**KIRKLEES METROPOLITAN COUNCIL
INVESTMENT & REGENERATION SERVICE**

DELEGATED DECISION TO DETERMINE PLANNING APPLICATIONS

| Reference No: | 2026/62/90537/W |
| Description: | Installation of 1BT Street Hub, incorporating 2 digital 75inch LCD advert screen and associated BT Phone Kiosk removal (within a Conservation Area) |

Drawing Title
PROPOSED SITE PLAN

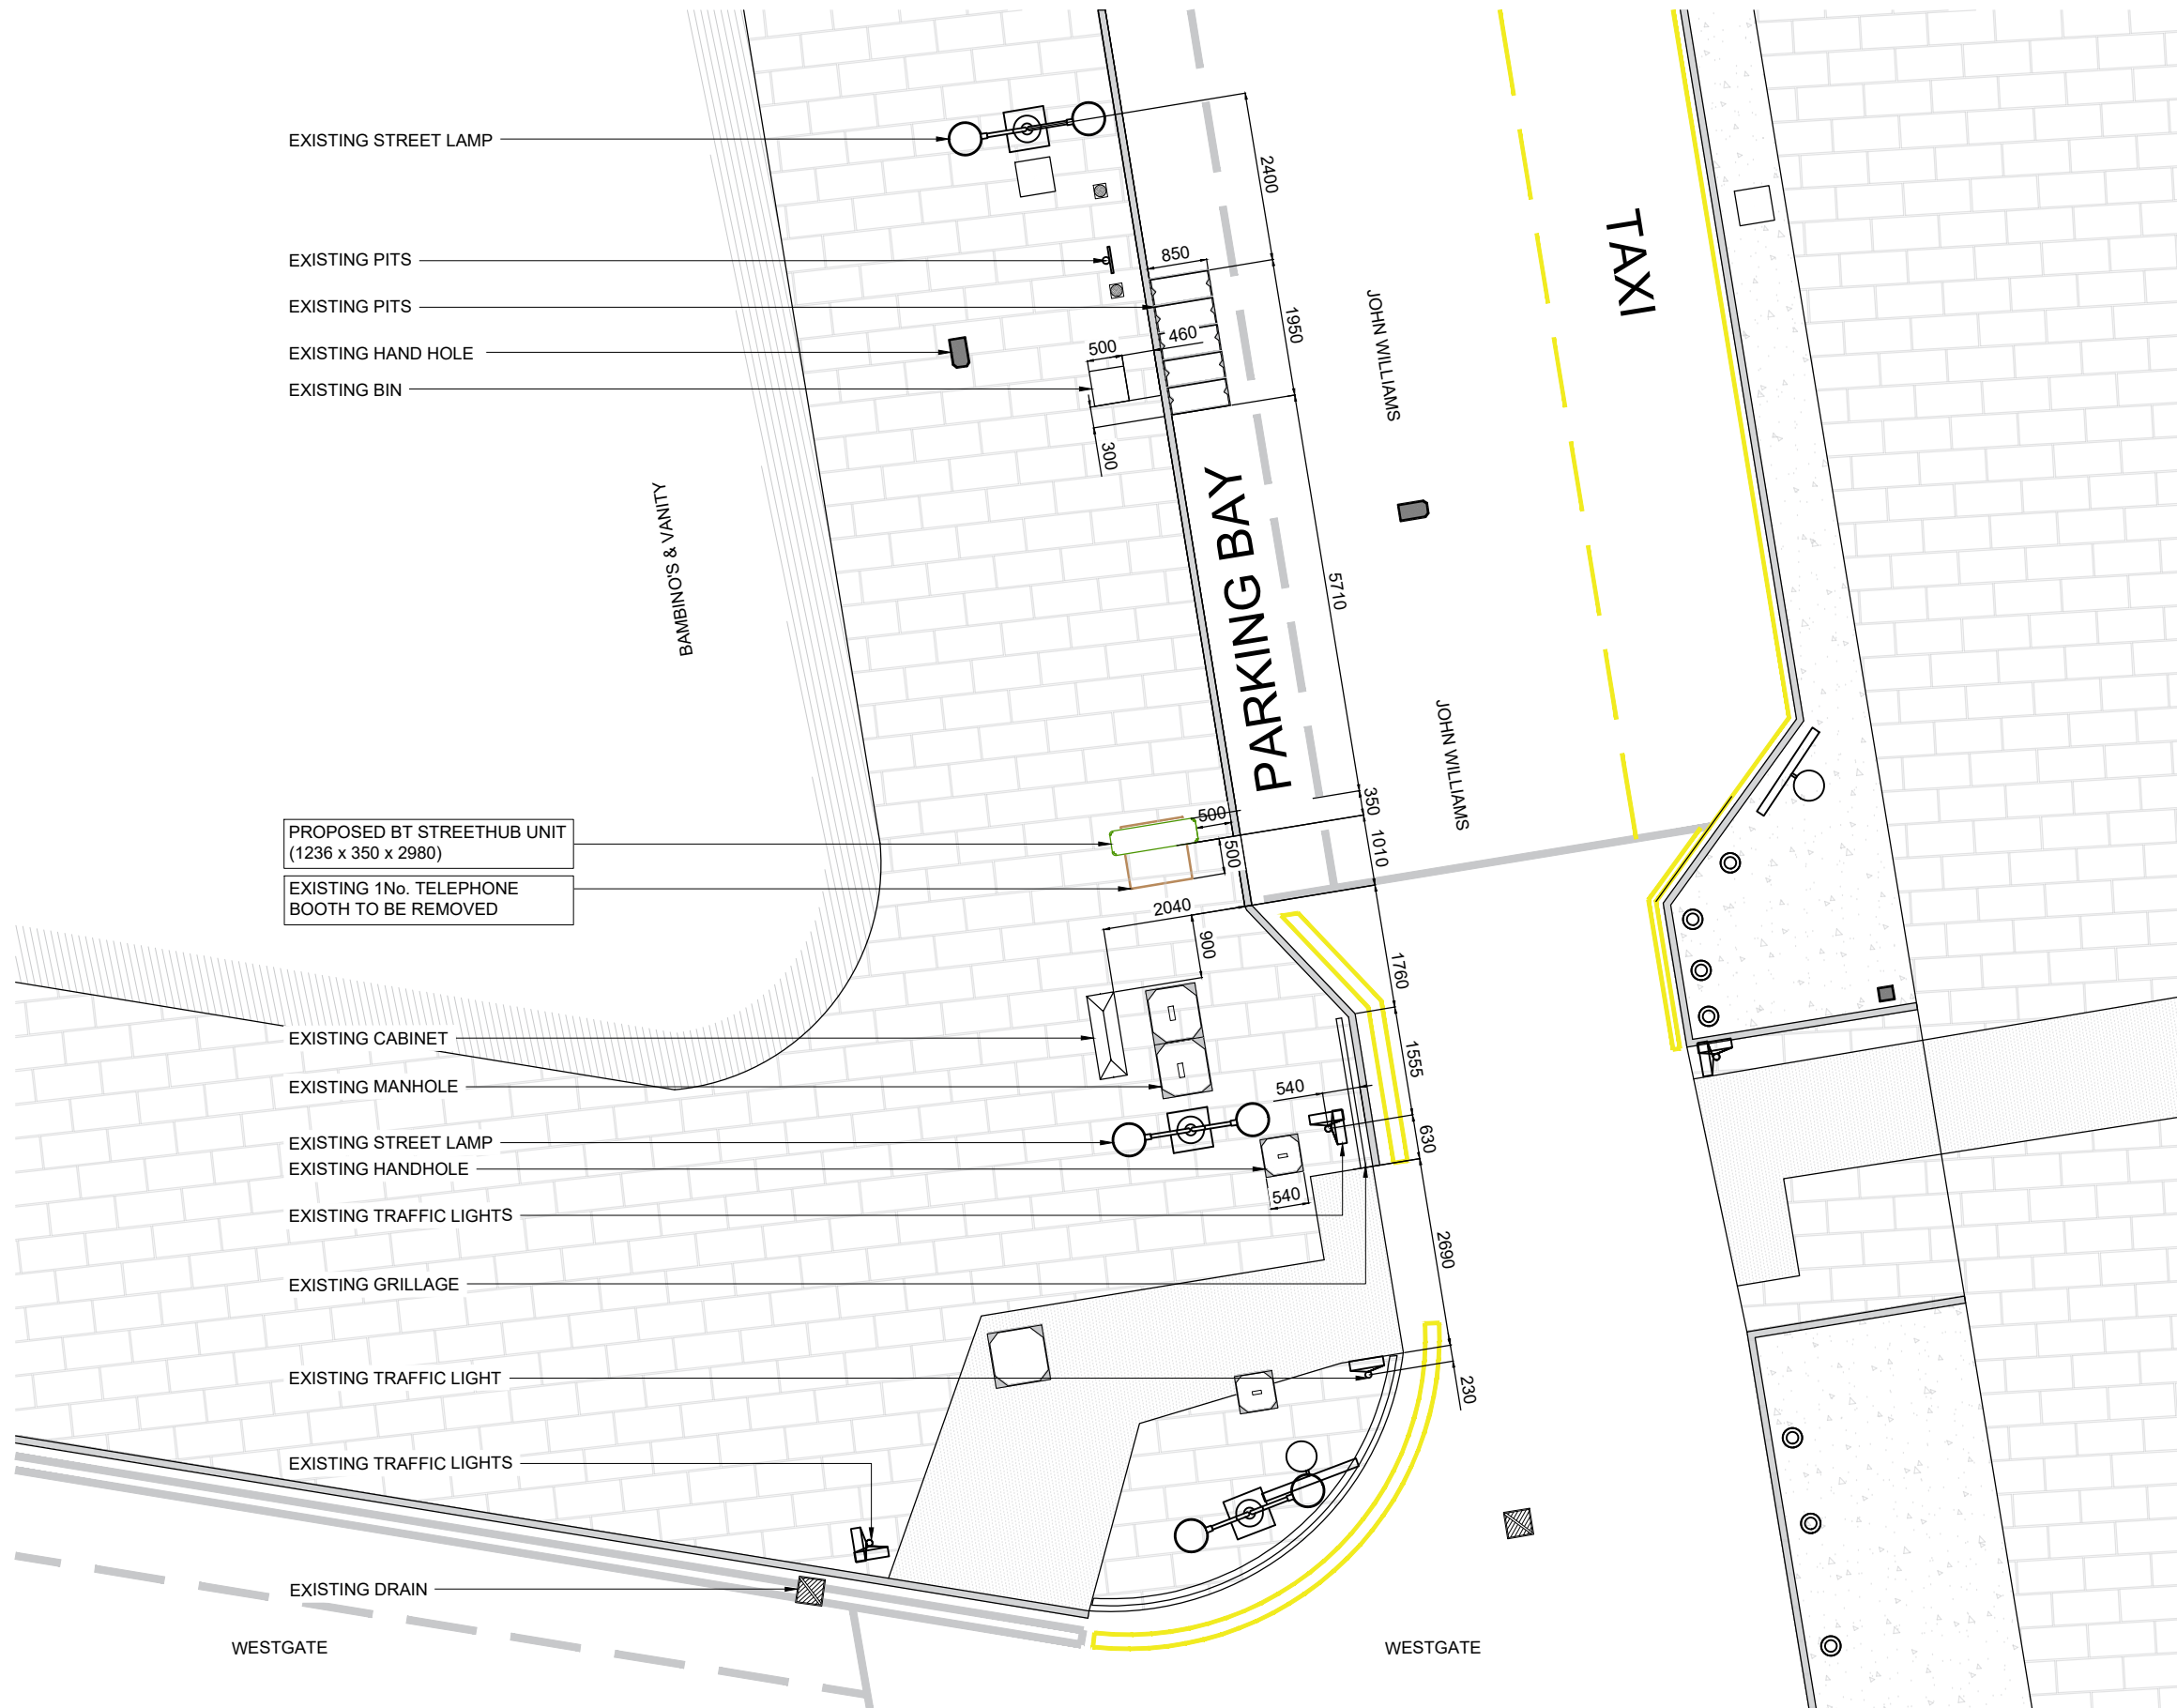
In some locations, BT Street Hubs may give rise to increased interference with pedestrian flow and vehicle-pedestrian intervisibility, being wider and less visually permeable than the existing telephone kiosks they would replace. In this instance, the Hub replaces a single call box in a location with existing street clutter which restricts pedestrian flows. The proposal would be wider than the existing call-box.

Whilst the further constriction of space for pedestrians to navigate the street would occur, it is considered that the further impact of the Street Hub in replacement of the existing Call Box would be such that there would be no material increase in impact to pedestrian using this part of the highway in relation to the space between the existing buildings and the Street Hub and refusal on such grounds could not be substantiated in this case.

Drawing Title
EXISTING AND PROPOSED ELEVATIONS

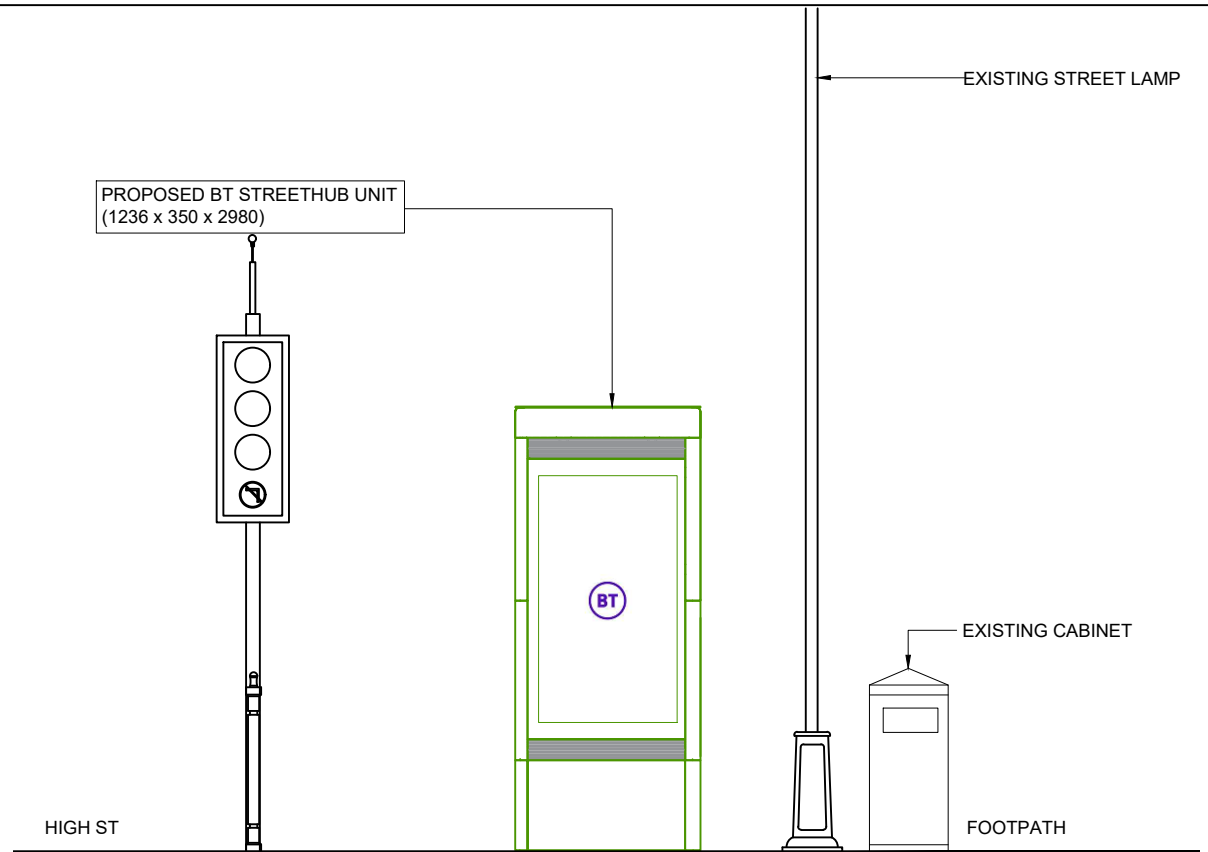
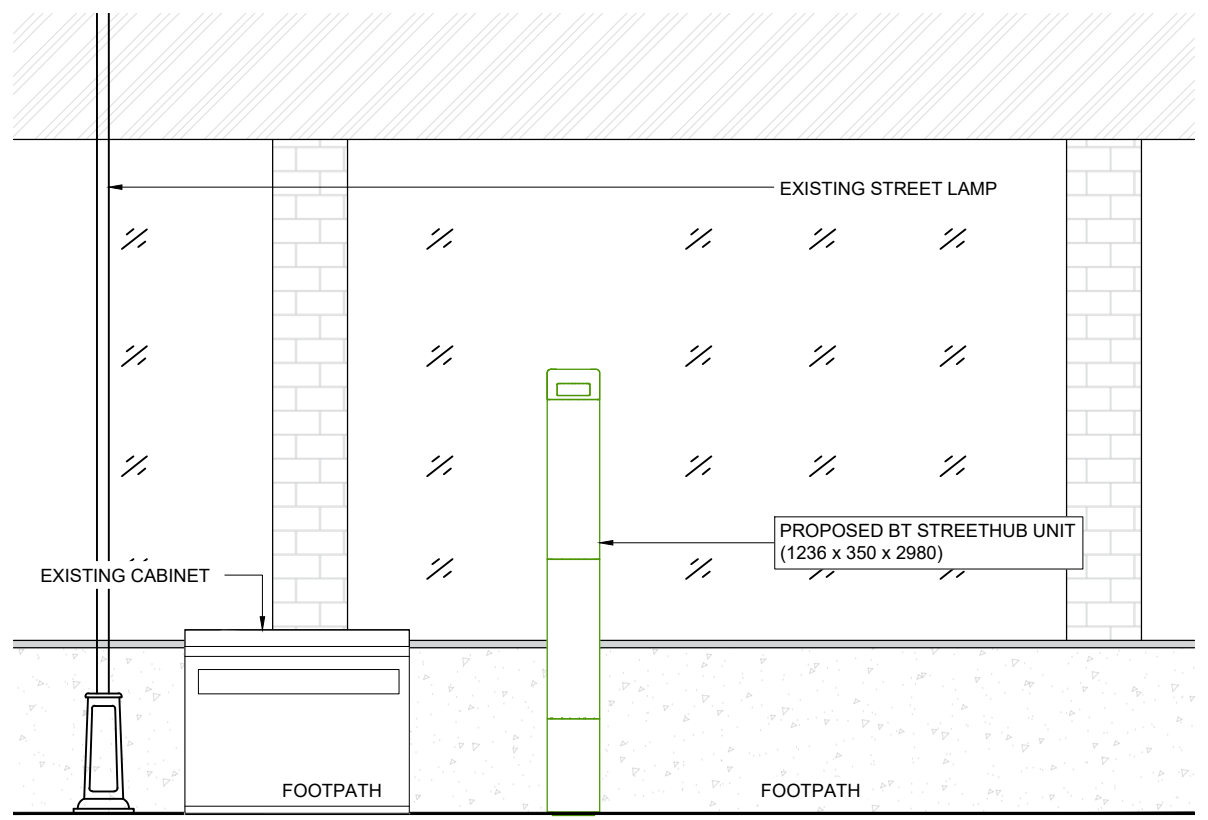
The sign would be viewed in this context with a backdrop of historic buildings and their setting within the wider Conservation Area. There is currently a number of structures and other street furniture in this part of the street, the proposal would see a reorientation of the site with the footprint of the existing call box altered such that it takes up more of the width of the pavement. The proposal would result in a structure of increased size and prominence which would be further exacerbated by the intention to incorporate illuminated signage upon the structure.

The removal of a single phone box would be a modest enhancement to the Conservation Area and the wider Town Centre. However, the introduction of a further 3m high structure featuring a pair of display panels would add further illuminated street clutter which would, especially in the context of already existing digital display screens, detract from the character of the area and cause cumulative harm to the conservation Area and also the setting of nearby listed buildings. It would thereby conflict with both Huddersfield Blueprint initiatives mentioned above and the aims of Policies LP17(a), LP24(a) and LP35, and also those of Chapter 16 of the NPPF, and the Council's duty under sections 66 and 72 of the Planning (Listed Buildings and Conservation Areas) Act 1990,

It is inevitable that the introduction of internally illuminated LED advertisement screen displays with changing of static images would draw the attention of road users and pedestrians to a significantly greater degree than the existing non-illuminated static signs displayed on the call box. These would draw the eye of road users at moments which require care and attention to safely negotiate a sharp bend which, whilst signalled, may cause confusion or distraction for drivers in relation to changing of the lights.

1. The proposed Street Hub would include illuminated screens on both sides. These are an integral part of the development under consideration. The proposed Street Hub and digital display screens, owing to their scale, prominent siting, and means of illumination, would be a visually incongruous and intrusive feature that would cause harm to the significance of the Huddersfield Town Centre Conservation Area, in which there are several listed buildings close by. The public benefits

1. The proposed Street Hub would include illuminated screens on both sides. These are an integral part of the development under consideration. The proposed illuminated screens, by virtue of their siting, illumination and the orientation of advertisements displayed, and by reason of conflicting with the clarity and effectiveness of a signalised junction, would create an unnecessary distraction to road users and pedestrians along a well-used vehicular and pedestrian route in Huddersfield town centre. This would be to the detriment of public and highway safety and the local highway network adjacent to the site, and thus contrary to Policy LP21 of the Kirklees Local Plan.
